**Albuquerque Studios Master Plan
Development**

Traffic Impact Study

September 13, 2021

HT#R16DA3006A
Received 9/14/2021

Synchro Arterial LOS on University Blvd North of Crick Ave

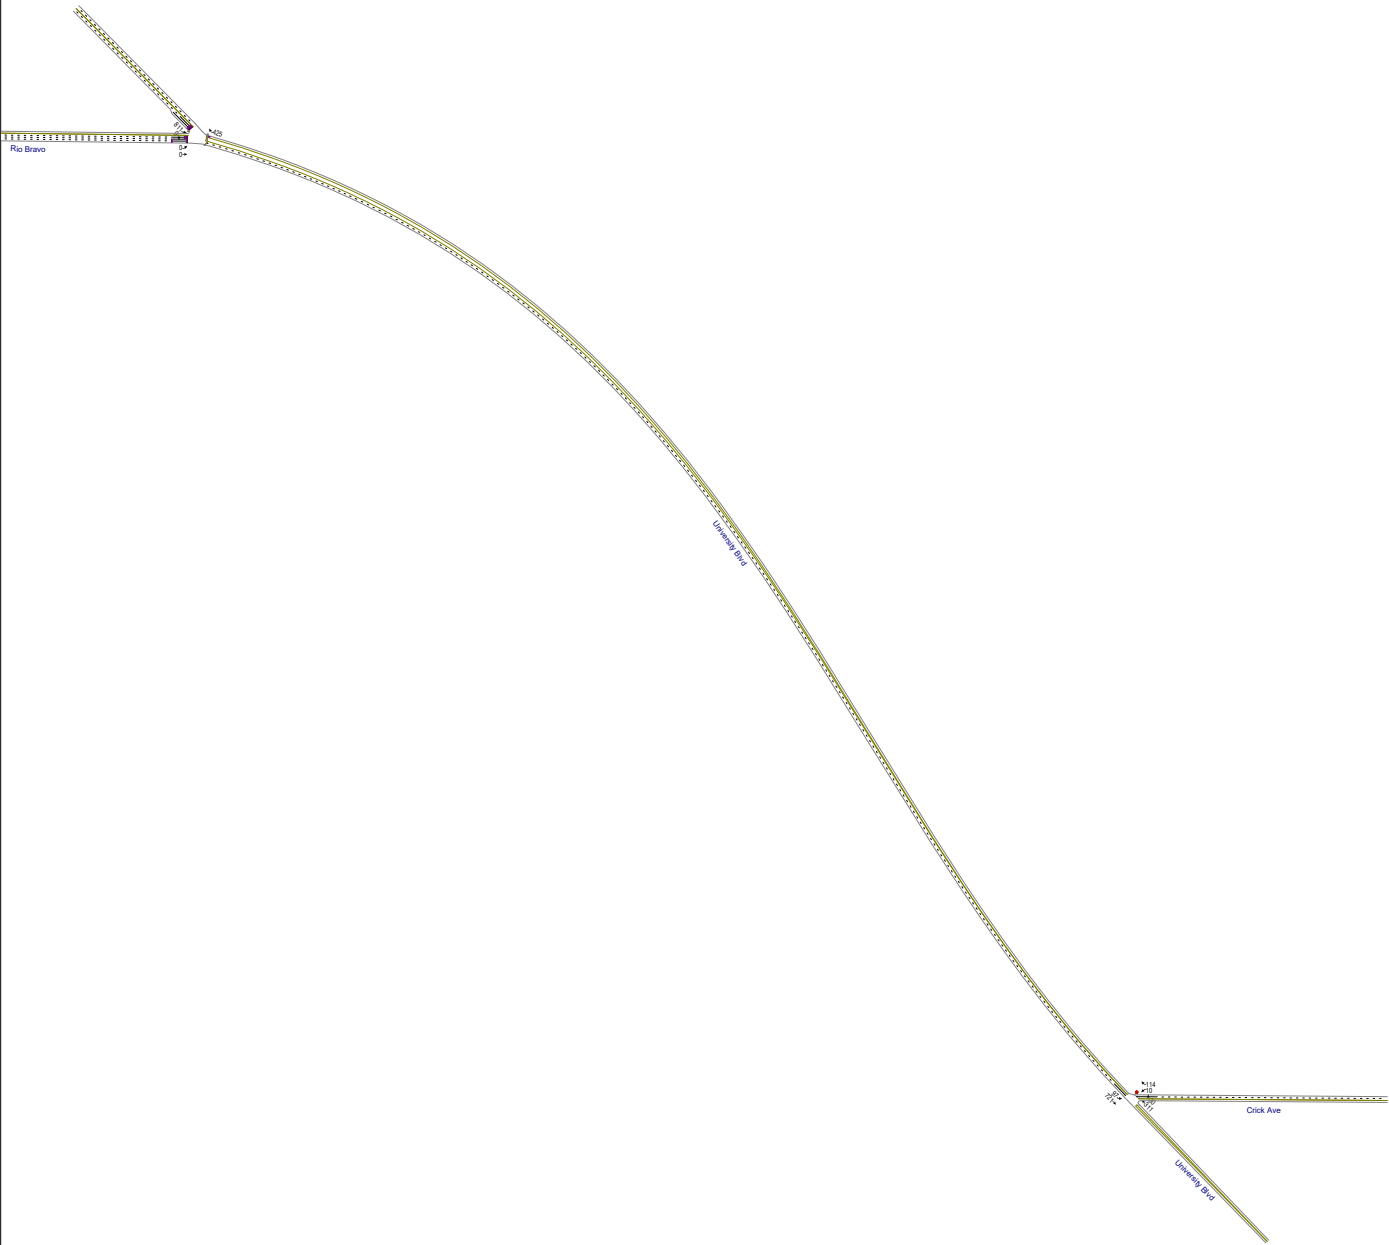
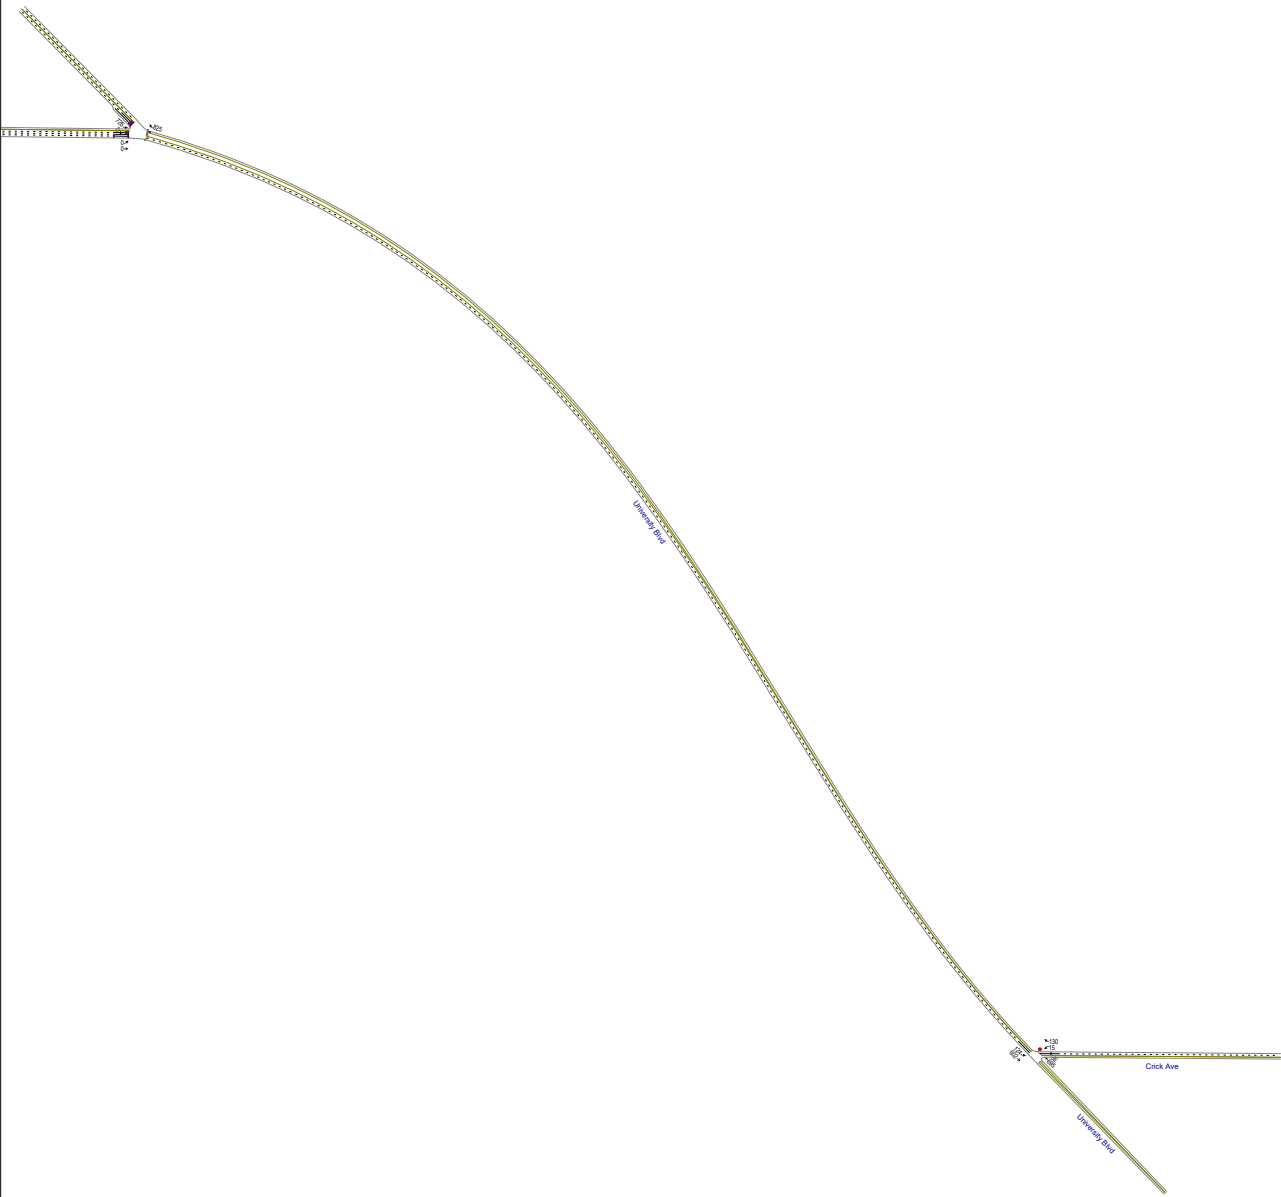
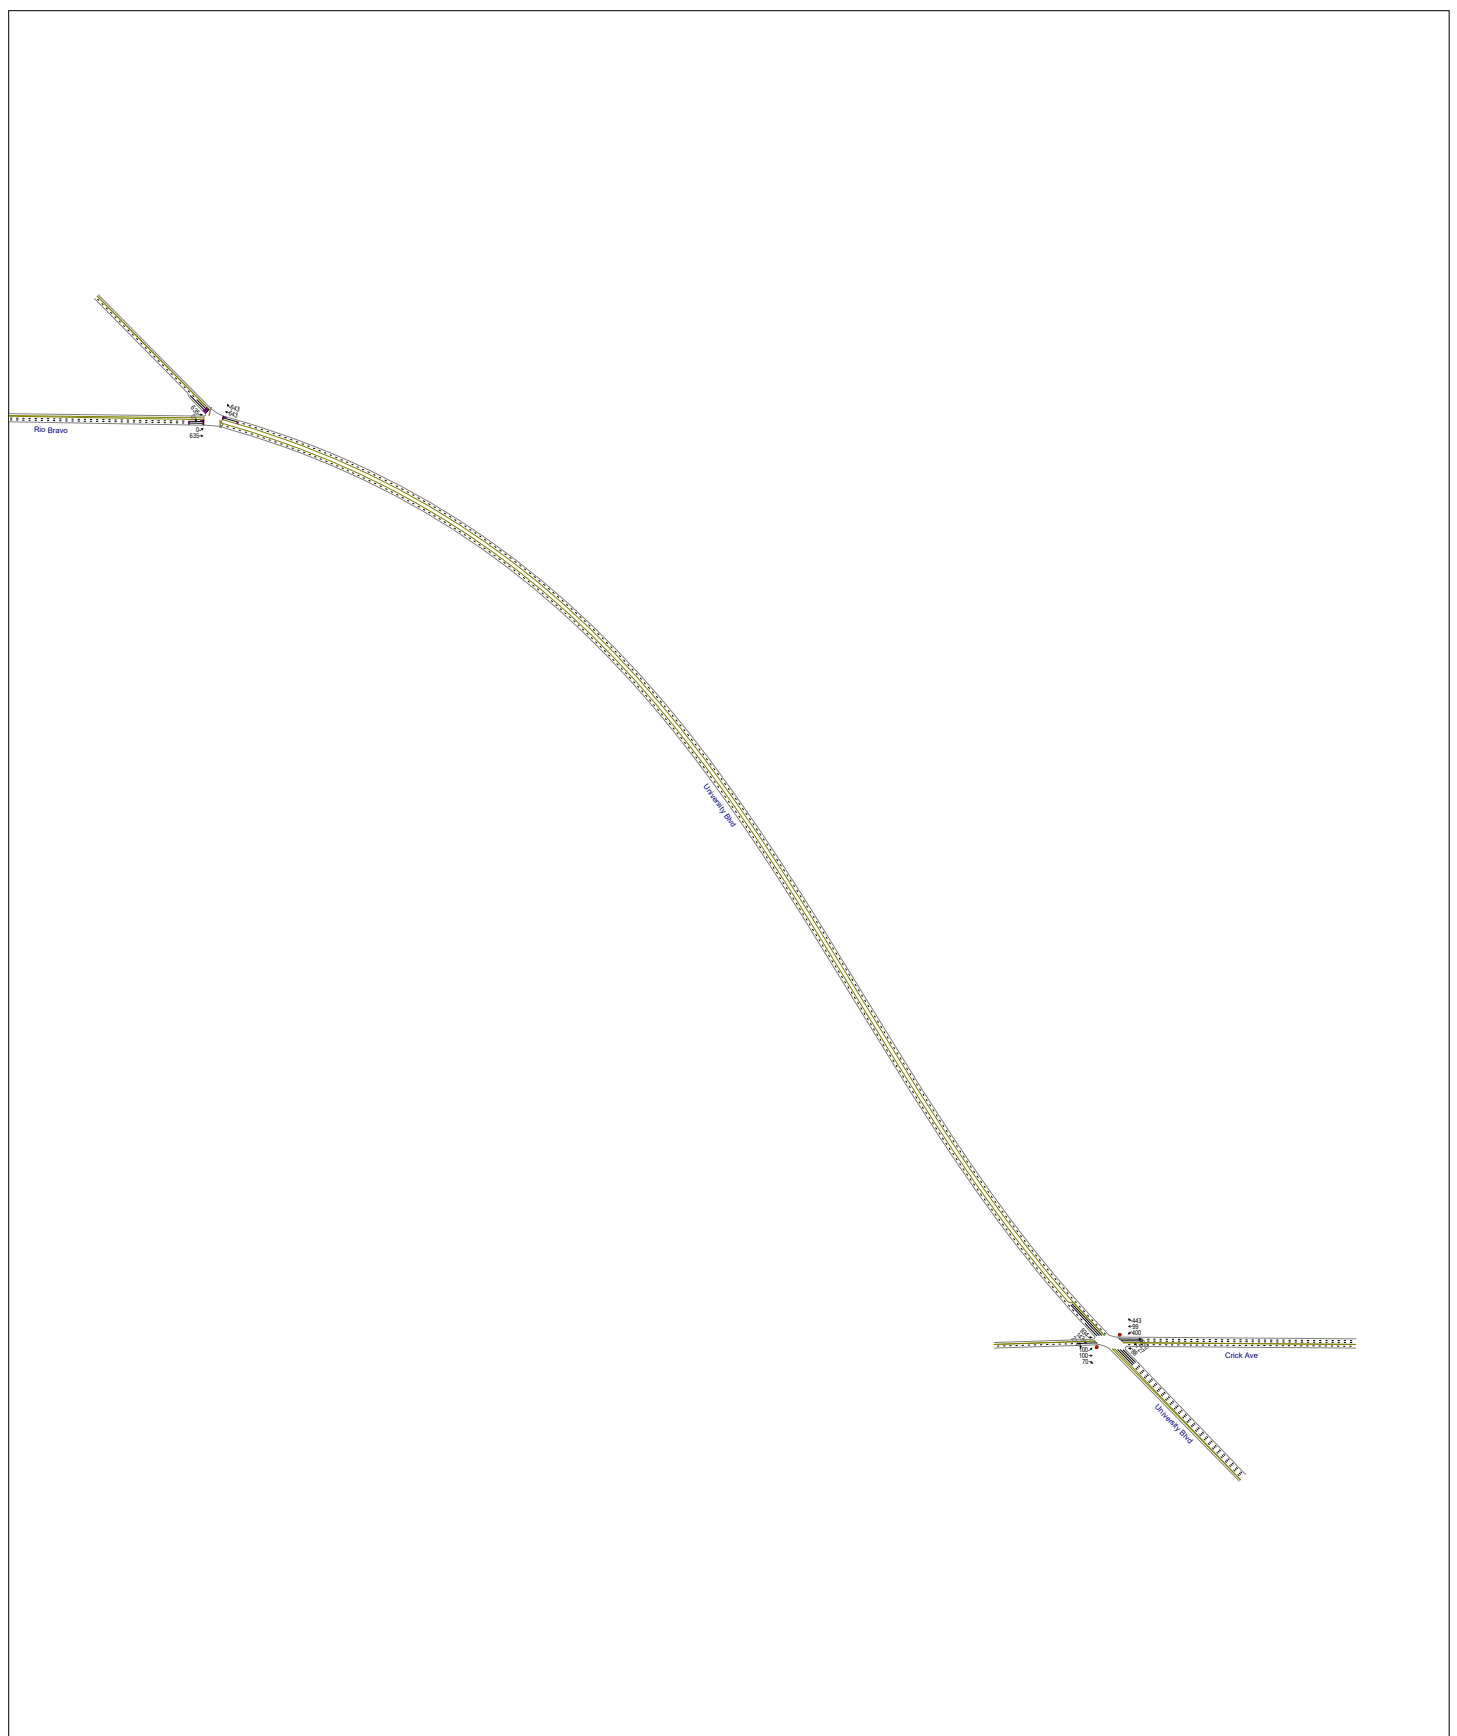
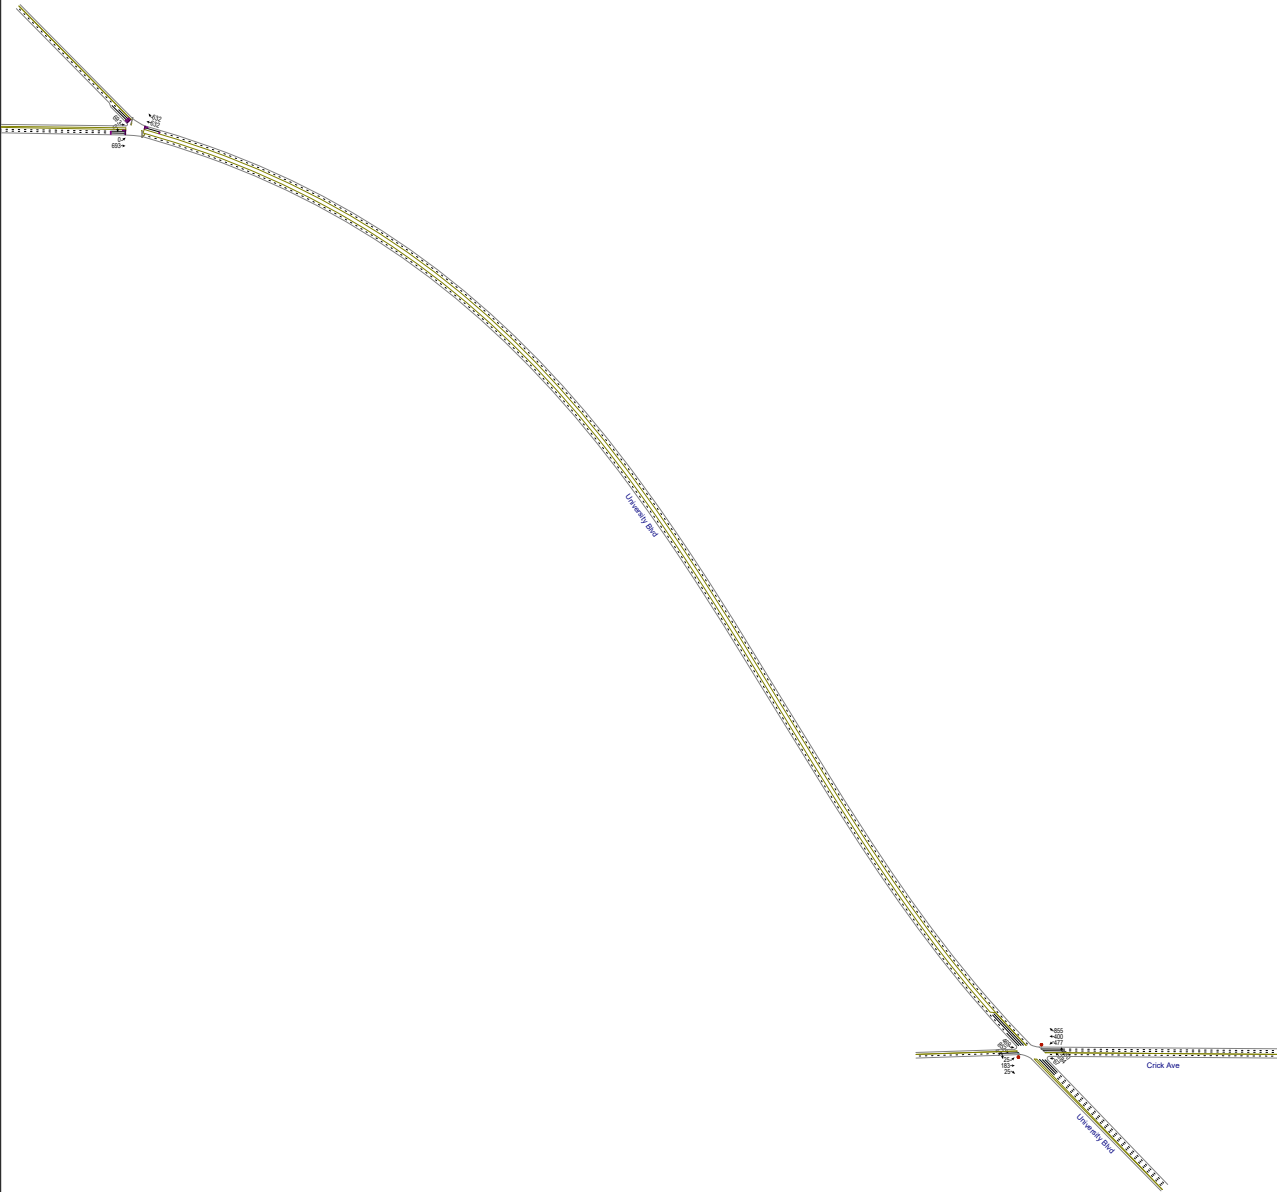
1. Evaluate the LOS on University Blvd. north of Crick Ave. This should include the traffic from the Montage developments and the Bernalillo County athletic fields, if the data is available. If the other development's trip distribution and traffic volume is not available perform the LOS for University using the background and build year traffic from the Netflix development. Provide mitigation suggestion if needed.

*A summary of Level of Service (LOS) (Arterial) for University Blvd. north of Crick Ave. is provided below: *Synchro Analyses report is attached.*

<i>Implementation Year Peak Hour AM, PM</i>	<i>Horizon Year Peak Hour AM, PM</i>
<i>University Blvd</i>	<i>LOS A, LOS A</i>	<i>LOS C, LOS C</i>

Note: Additional at-grade signalized intersections that may be proposed north of Crick Ave in the future on University Blvd., will reduce the green time available to the major street (University Blvd). Currently University Blvd is operating in an un-interrupted flow condition (no traffic signals). Installation of traffic signals in the future may increase the need for additional approach lanes at the signalized intersection on University Blvd. to maintain/achieve an acceptable delay LOS thru the intersection during the peak hour conditions.
